<b>Application Ref:</b>	3/2025/0887			 Ribble Valley Borough Council <a href="http://www.ribblevalley.gov.uk">www.ribblevalley.gov.uk</a>
<b>Date Inspected:</b>	25/11/25	<b>Site Notice:</b>	N/A	
<b>Officer:</b>	LW			
<b>DELEGATED ITEM FILE REPORT:</b>				<b>REFUSAL</b>

<b>Development Description:</b>	Proposed construction of a detached garage in the front garden.
<b>Site Address/Location:</b>	53 Knowsley Road, Wilpshire, BB1 9PN.

2 Garage Attic  
1:50

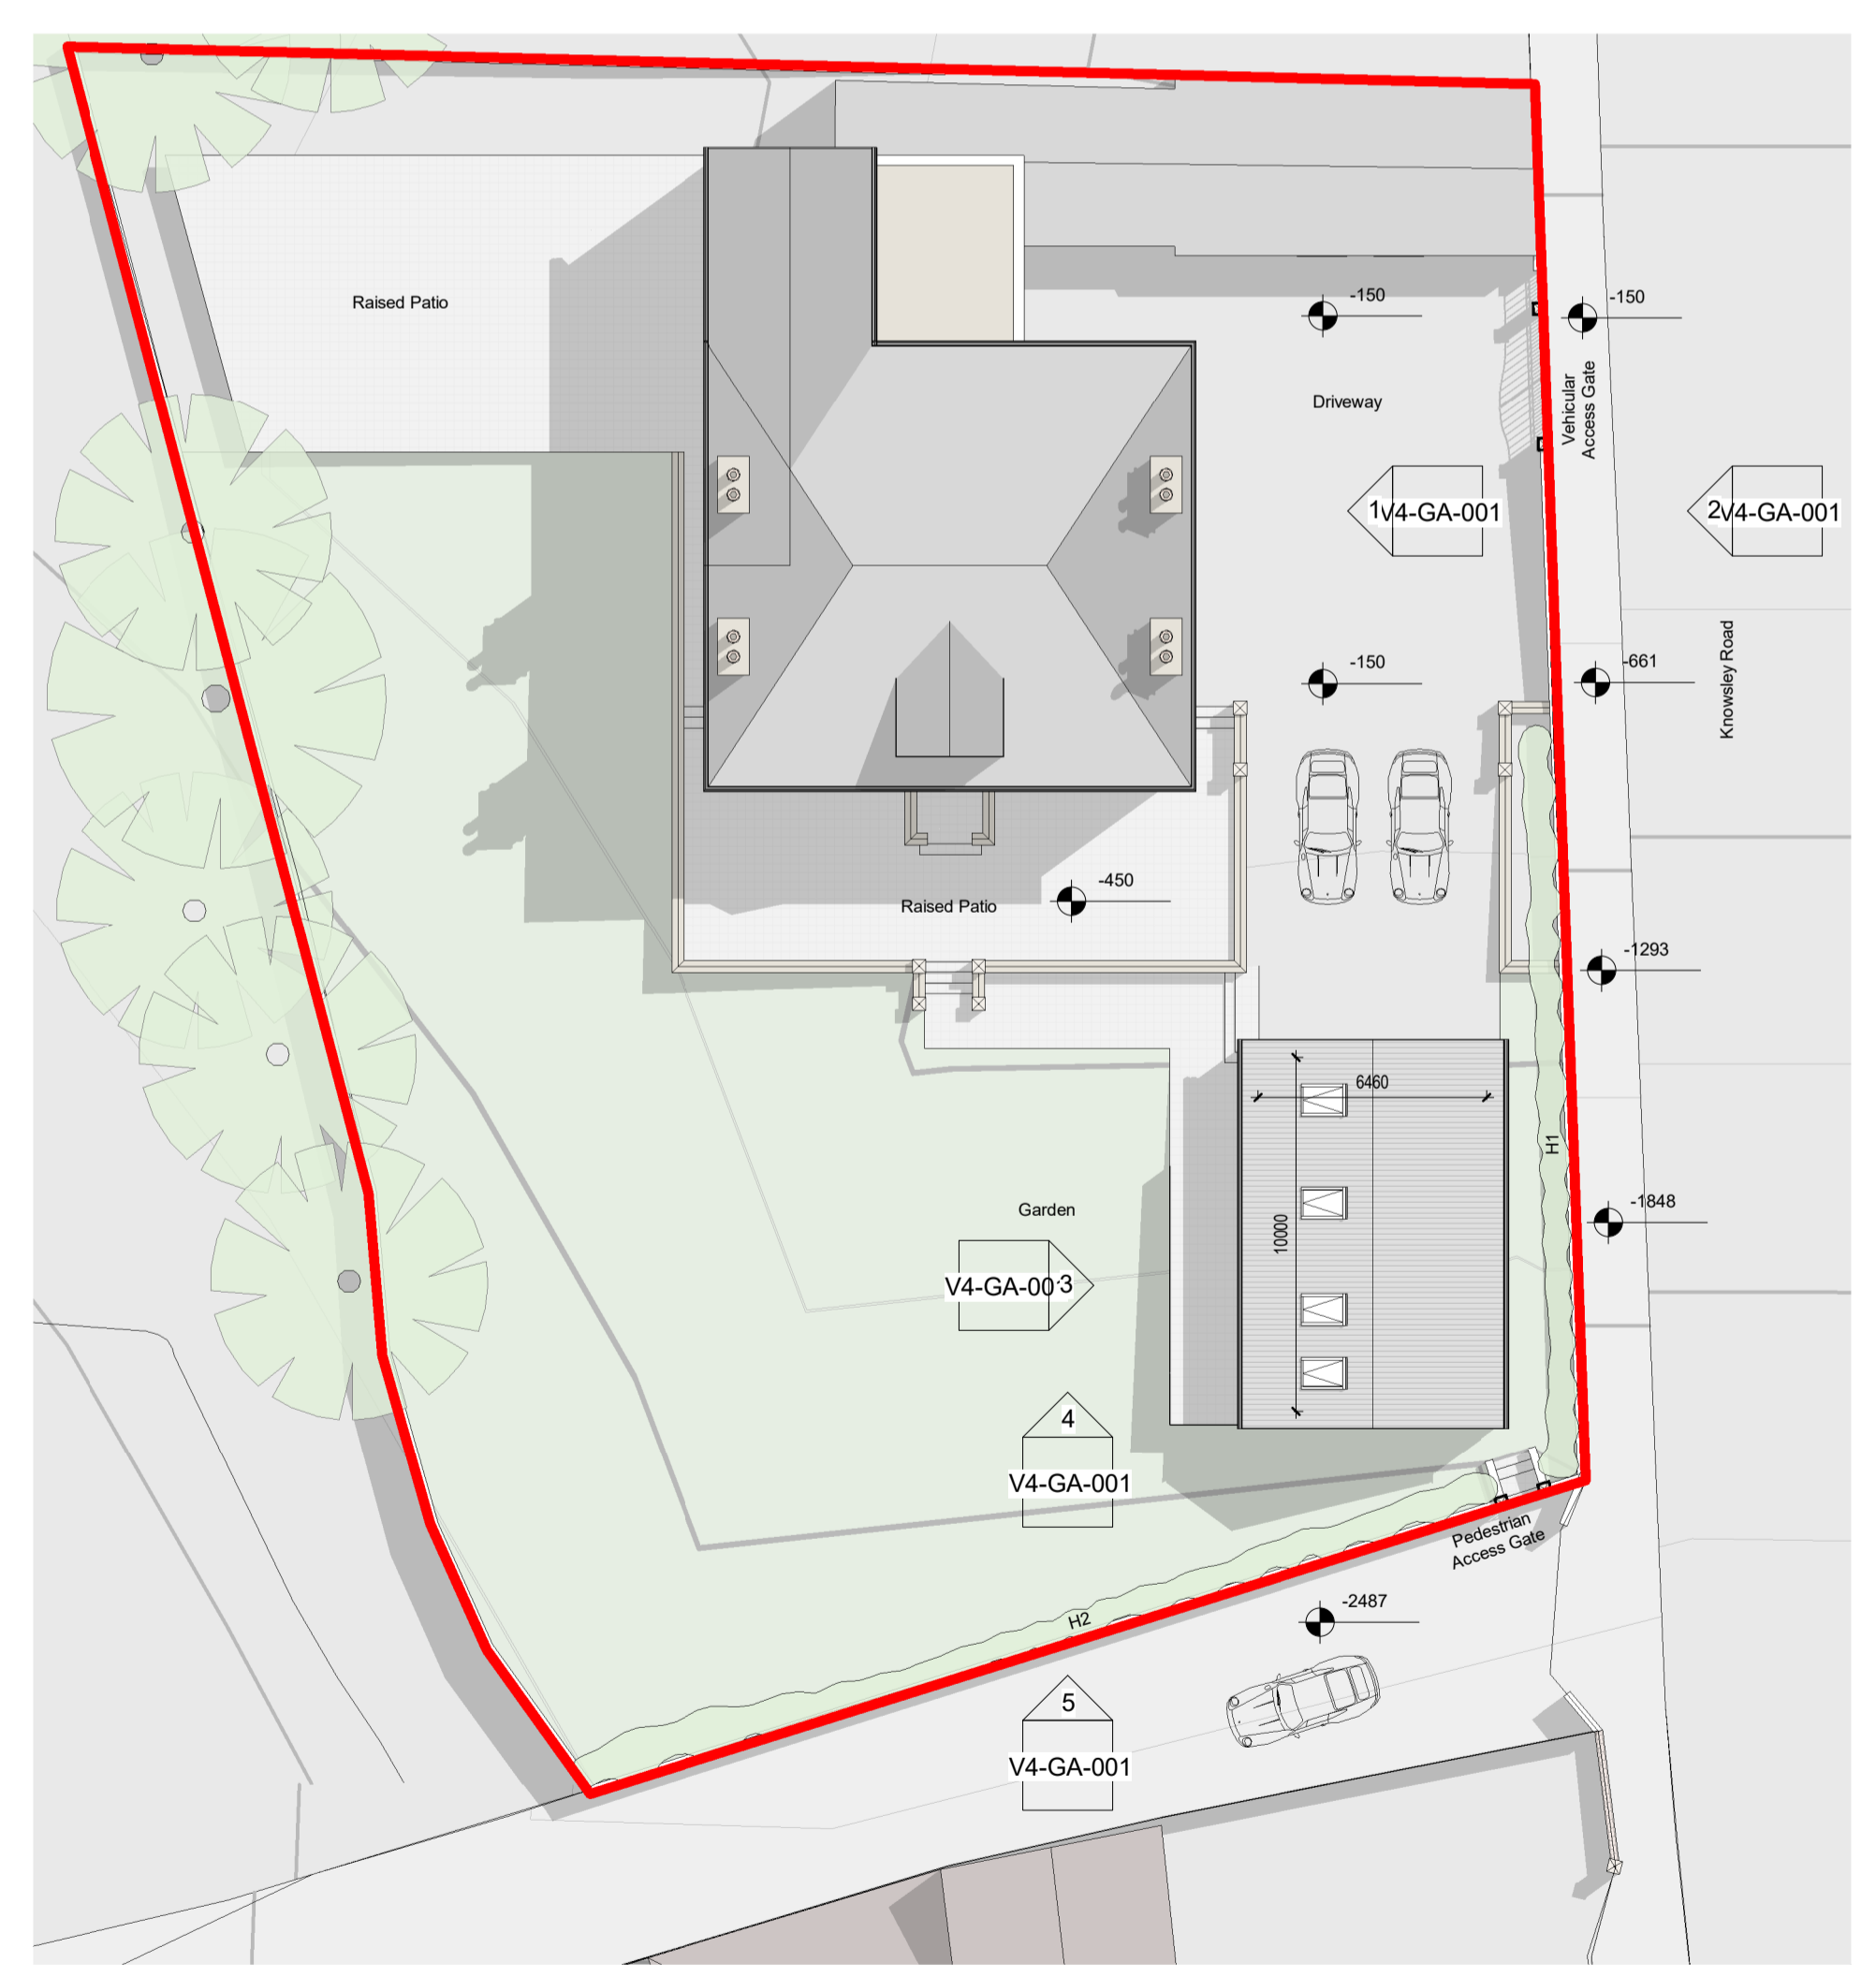
The proposed outbuilding would comprise a substantial footprint measuring 10.7m by 7.2m, resulting in a building of such a size that the proposed development would begin to visually compete with the host dwelling as a large building in its own right, severely reducing its incidental appearance. The harmful effect of this would only be exacerbated by the considerable volume that would be incorporated at roof level in order to accommodate a first-floor attic, as well as the highly prominent location of the building within the south-eastern corner of the site, forward of the principal elevation of the application property and directly adjacent to western boundary of the site. The development would therefore have a clear visual impact upon the street scene, with the size and scale of the building being such that it would adversely affect the proposal site's spacious qualities.

Moreover, the submitted plans show the building to accommodate a double garage at ground floor. However, upon review of the internal dimensions of the garage, one of the proposed parking spaces would fail to meet the recommended minimum internal dimensions for a vehicular parking space, measuring just 4.9m in depth compared to the recommended 6m due to the location of the internal staircase. As such, the proposed double garage would likely only accommodate one vehicle. With this in mind, the size of the building is also considered to be excessive in relation to its proposed use.
